**KIRKLEES METROPOLITAN COUNCIL
INVESTMENT & REGENERATION SERVICE**

DELEGATED DECISION TO DETERMINE PLANNING APPLICATIONS

Reference No: 2020/62/90989/W
Site Address: 14, Edgerton Road, Edgerton, Huddersfield, HD1 5RB
Description: Erection of dormers and alterations (within a Conservation Area)
Recommending Officer: Ellie Worth

DECISION - Refused

CLIENT DETAILS 14 EDGERTON ROAD HUDDERSFIELD	DRAWING No 2019045(0-)-02		REVISION
	DRAWING INFO PROPOSED PLANS	SCALE 1: 50	DATE 08/11/19
			DRAWN BY JH

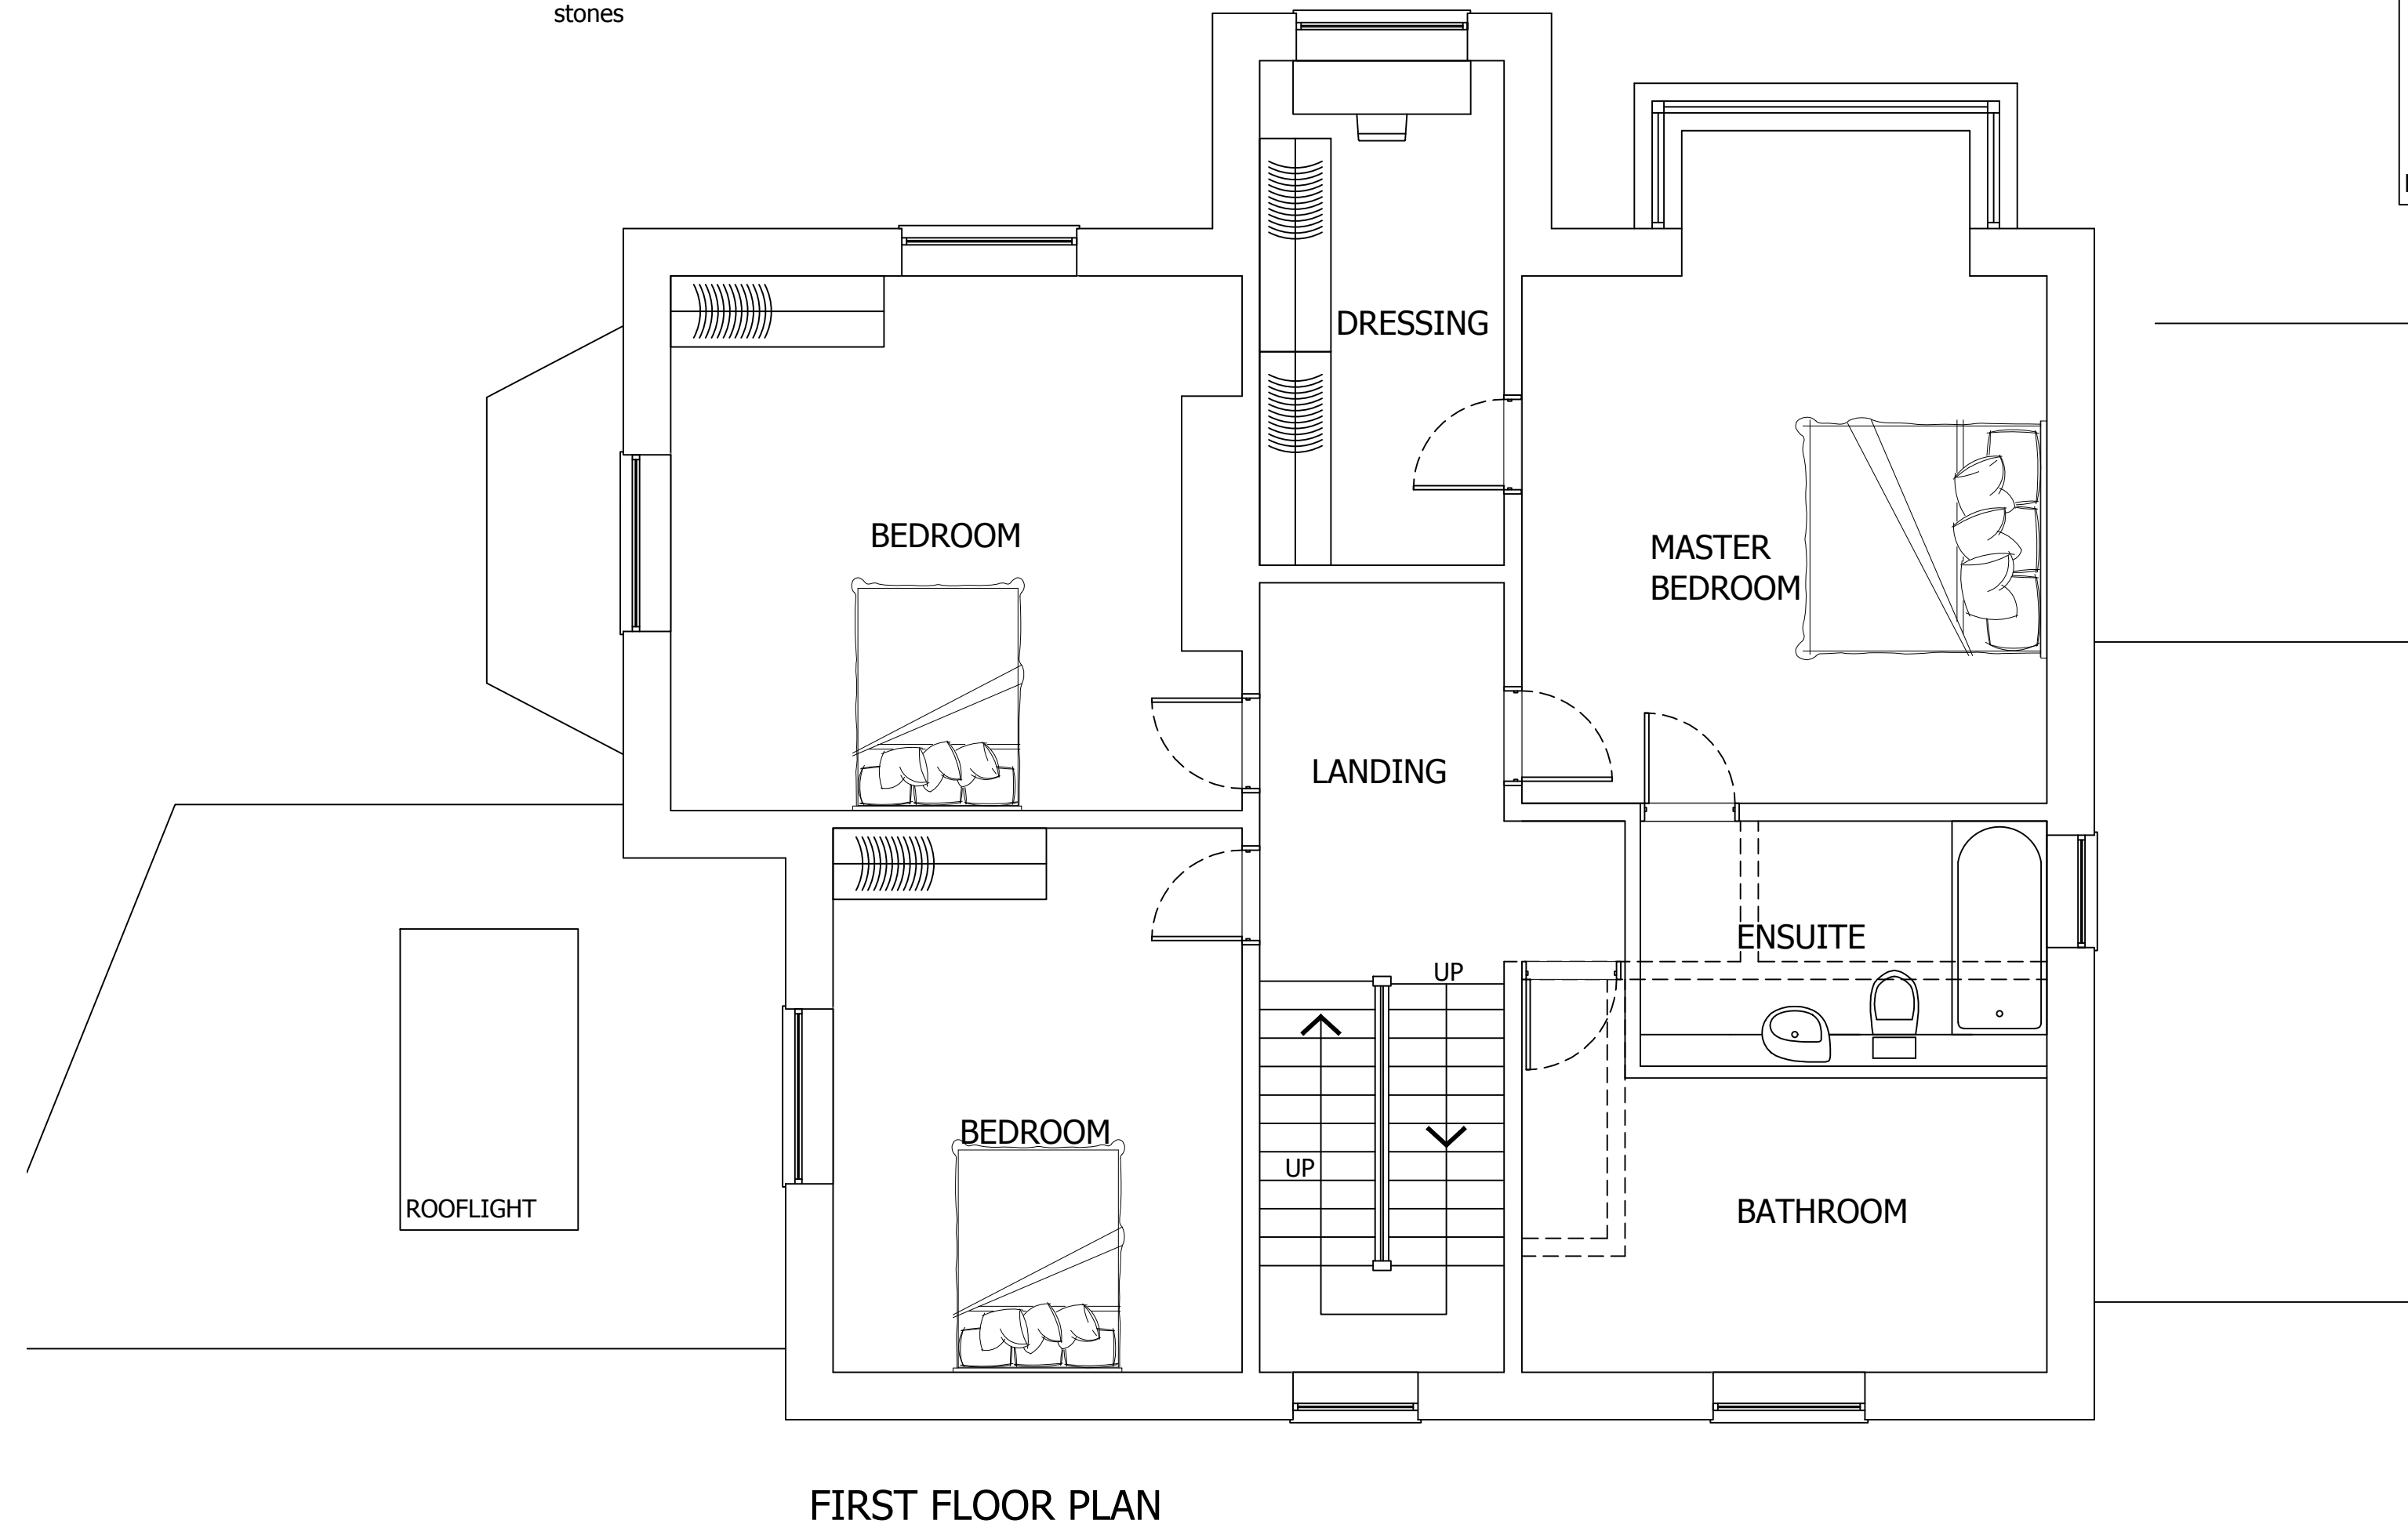
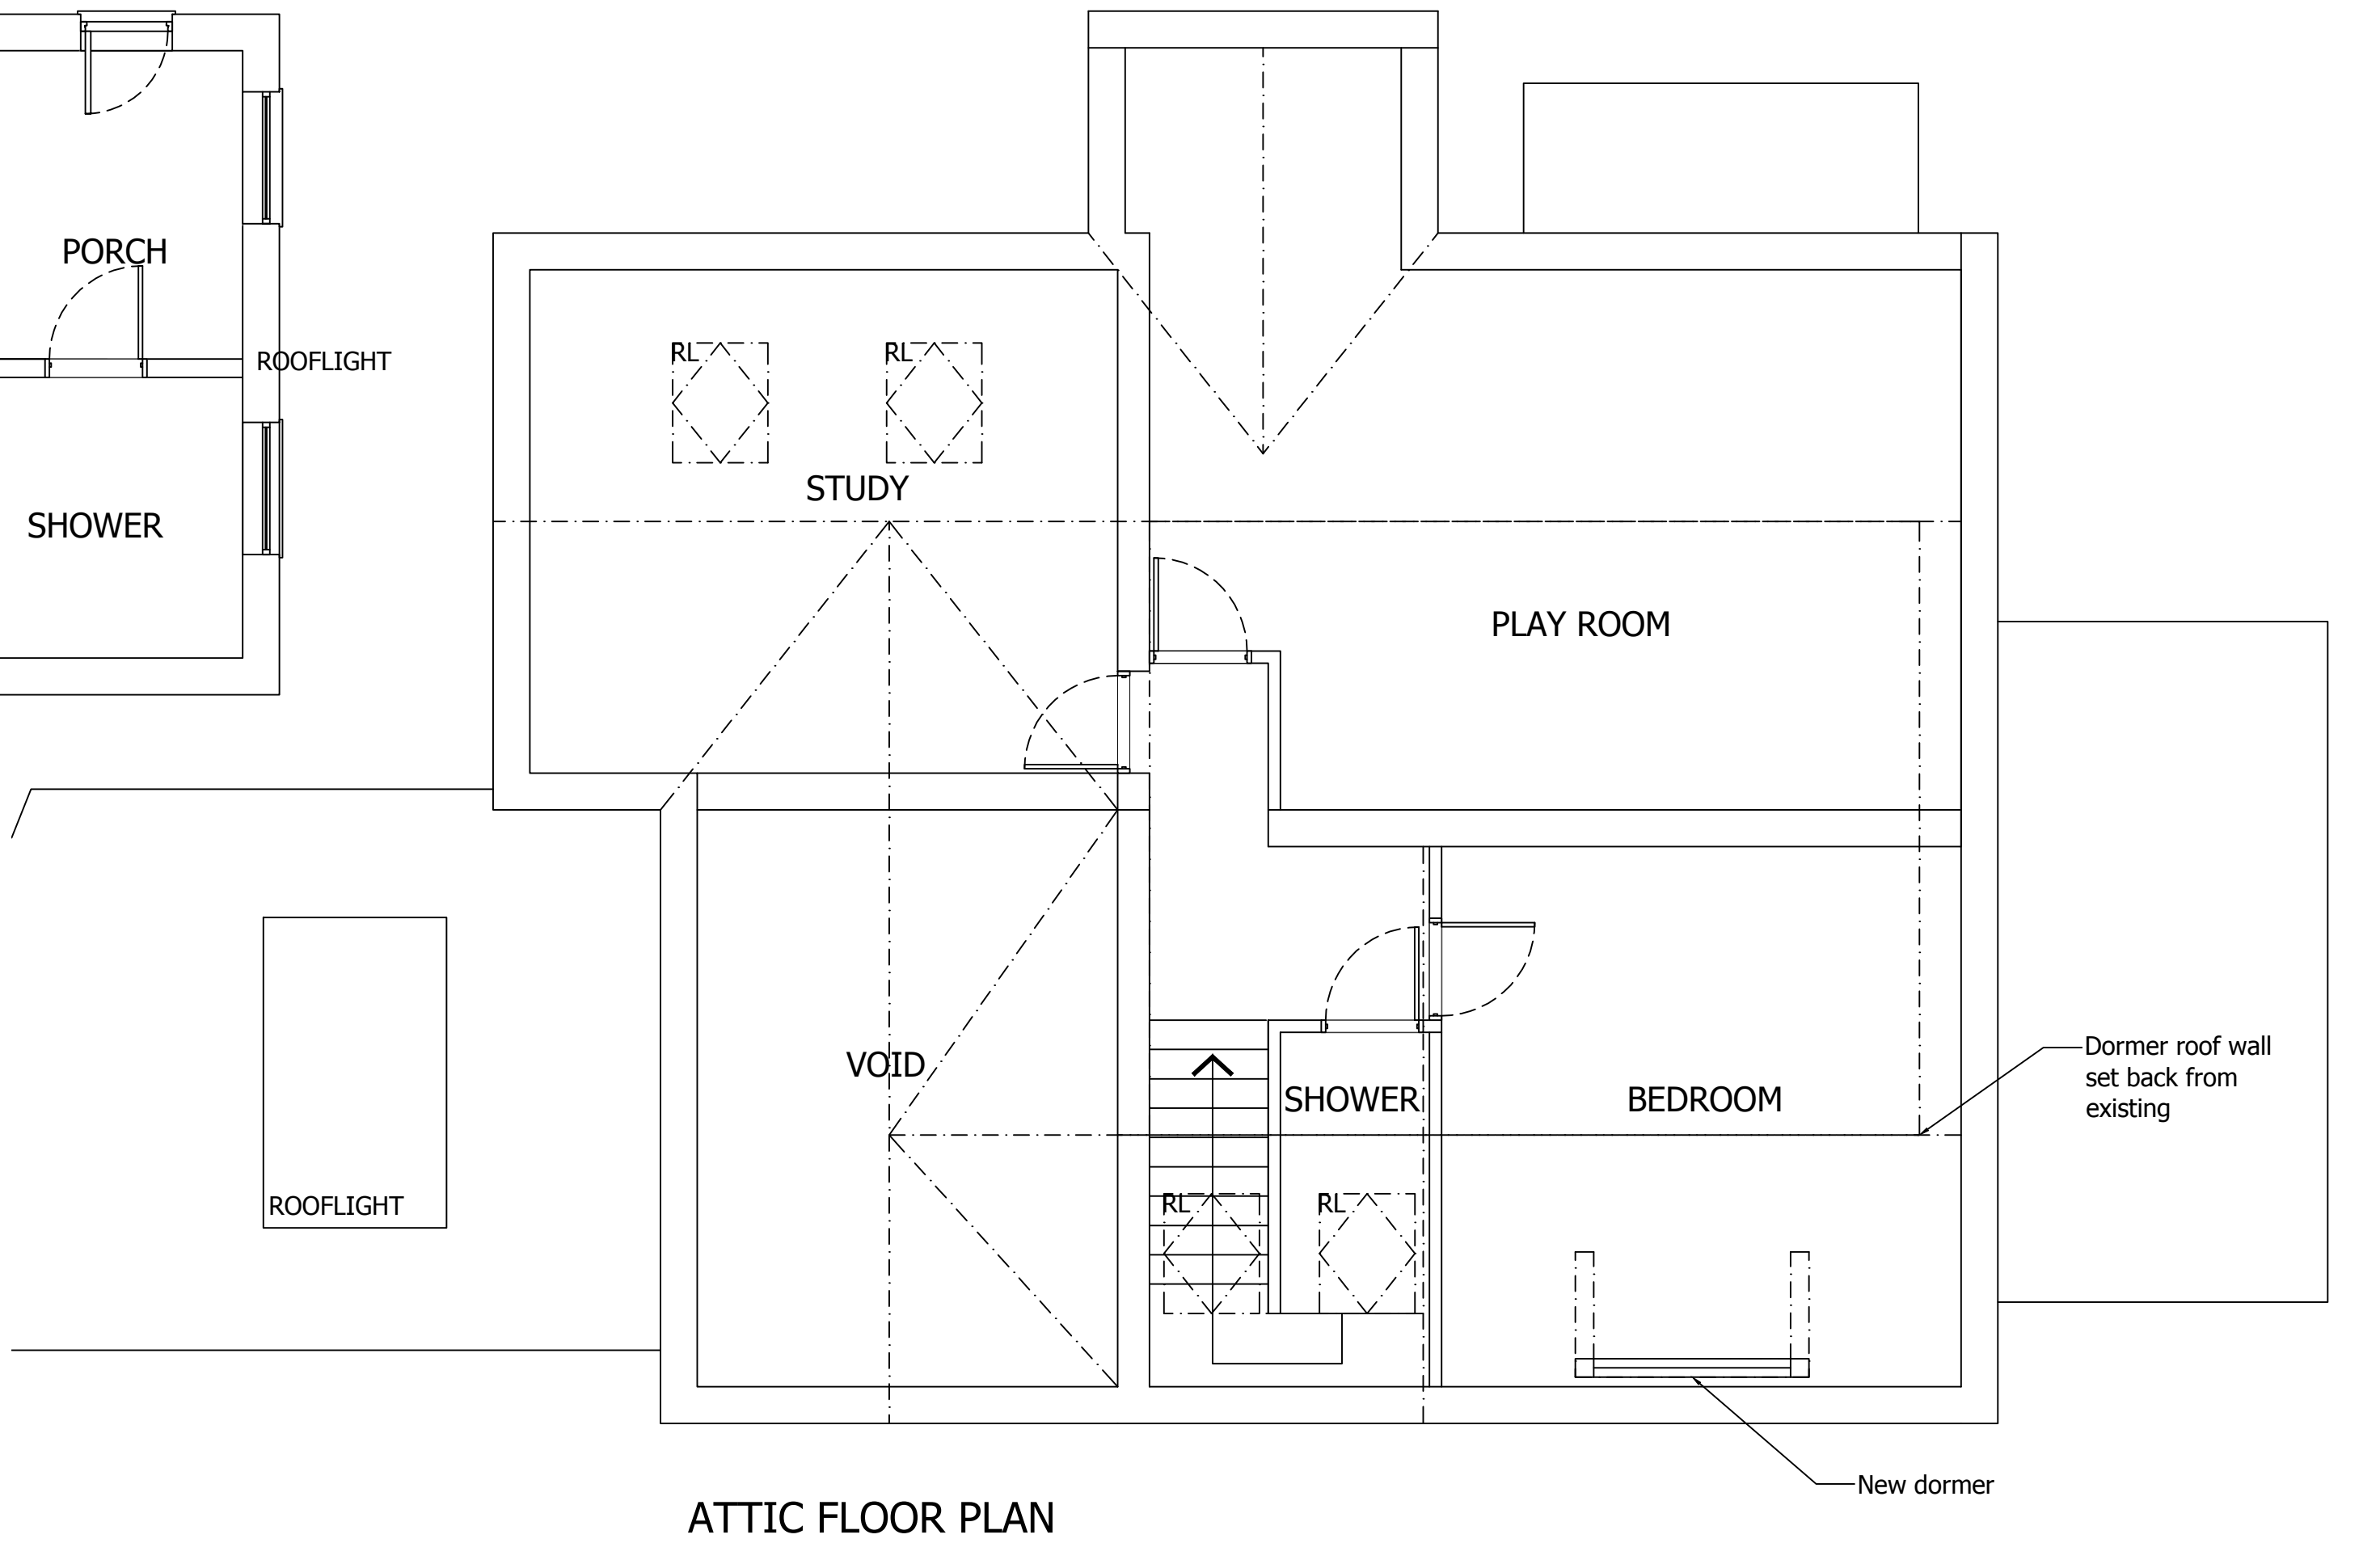
It is also noted that the lean to extension is still shown on the elevations plans. This is a discrepancy, as the agent has confirmed that the applicant is now only seeking permission for the dormers and roof lights.

Whilst significant amendments have been sought as part of this application, in order to remove both side extensions, concerns are still raised regarding the impact in which the flat roof dormer would have upon the character and appearance of Edgerton Conservation Area.

However, in this case, Officers have noted that dormer windows are not a common feature within the surrounding landscape, with the flat roof element appearing incongruous due to its size and scale. This has been proposed based on function rather than form and would be widely viewed from Edgerton Road. As such, the design of the dormer windows can not be supported.

Two dual pitched dormers would also be an addition to the development, however, on balance given their limited size and scale, any impact is not considered to be undue. This is due to the sympathetic design of these elements, in which would harmonise to an acceptable degree with the host property.

In this instance, KC Conservation and Design have been formally consulted, raising no objection to the roof lights, provided that these are conditioned as being of a 'Conservation' style. However, the flat-roofed dormer spanning the double pile roof, would be out of keeping of the area and therefore the development would cause moderate harm to the character and appearance of Edgerton Conservation Area. That harm would be less than substantial.

1. The proposed flat roof dormer by reason of its scale, spanning a large section of the roof of the host dwelling and flat roof design, would form an incongruous addition to the host dwelling, which would be widely viewed from Edgerton Road and the wider Edgerton Conservation Area. The proposal would therefore cause detrimental harm to the character and appearance of Edgerton Conservation Area and the setting of the surrounding Listed Buildings. This harm is considered to be less than substantial, however, as required by Paragraph 202 of the National Planning Policy Framework, great weight has been given to that harm in assessing the impact of the proposed development. Public benefits have not been demonstrated that would outweigh the harm caused in this case. The development would therefore be contrary to the Council's duties under the Planning (Listed Buildings and Conservation Areas) Act 1990, Policies LP24 and LP35 of the Kirklees Local Plan, the aims of the Councils House Extensions and Alterations SPD and Chapters 12 and 16 of the National Planning Policy Framework.
